The development of 82 Raikes Lane would lead to the proposed dwelling wall abutting the property boundary and therefore my driveway, leaving the space cramped.

The proposed balcony to the front of the house will be unacceptable as it will be overlooking my front garden so there will be no privacy.

Drawing Title
PROPOSED EXTN.

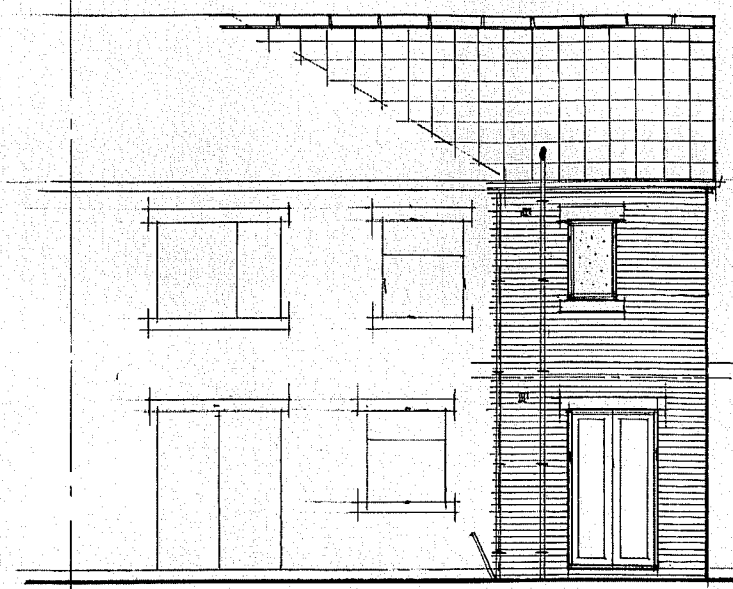
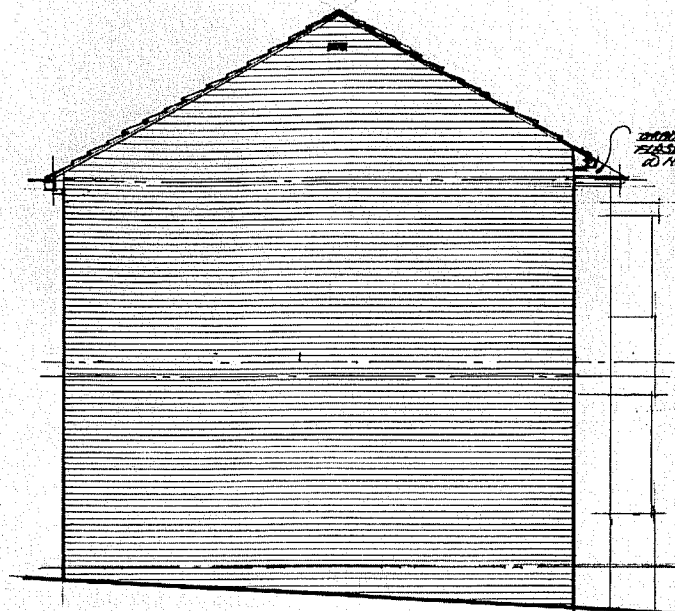
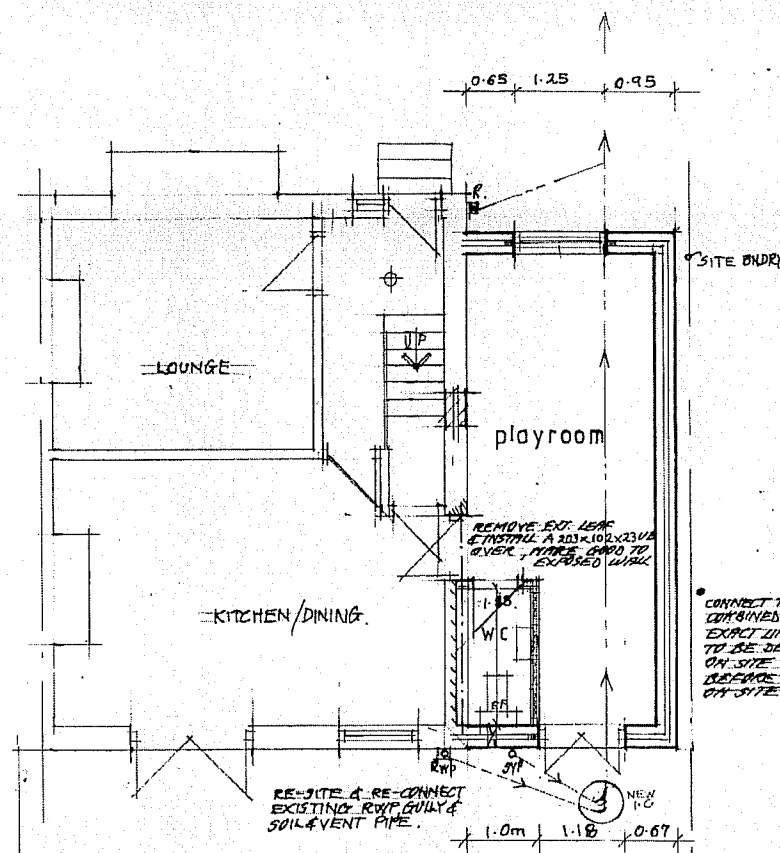
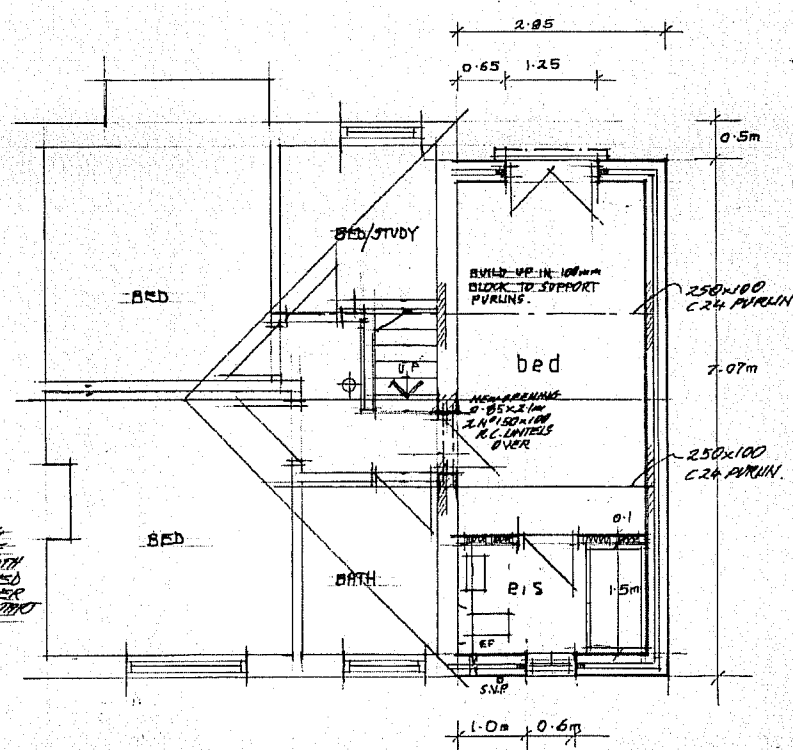
The two storey extension would block light to my driveway, as well as to both my front and back gardens through the day. I have a door on the side of

the house, the planned extension will block light coming through the window in the door.
